Development Facilitation Team (DFT) – Review Comments

DRB Project No: PR-2021-005684 Date: 8/14/2024 Agenda Item: #2 Zone Atlas Page: Q-16

Request: REPLAT OF TRACTS E AND F INTO THREE (3) TRACTS, F-1, F-2 AND F-3.

Application For: SD-2024-00094 – PRELIMINARY/FINAL PLAT (DHO)

TYPICAL STREET SECTION "E" (CRICK AVE) PARTIAL BUILD

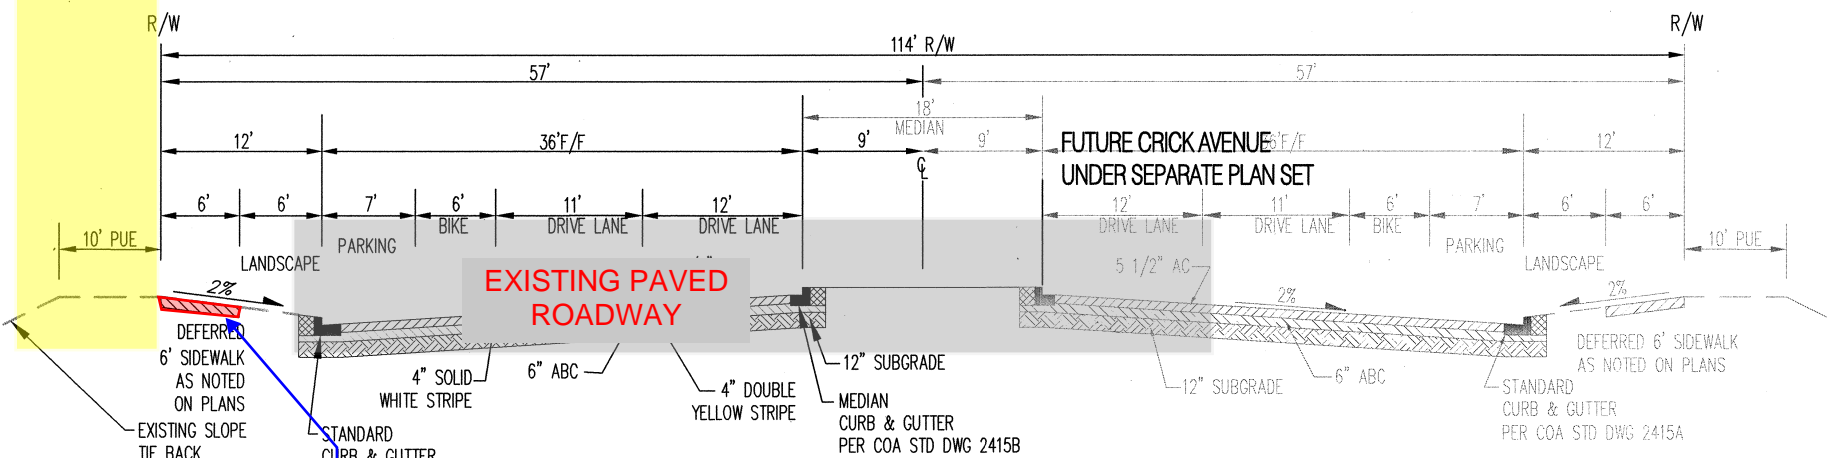
- Demonstrate compliance with *Section 7 of the DPM Table 7.2.29, Mesa Del Sol streetscape plan, and the Required Improvements section from 5-4(N) of the IDO.* *Regarding Sidewalk width requirements and the landscape buffer. *Confirm the construction detail for the IL-infrastructure List.*
Verification of standards per Transportation
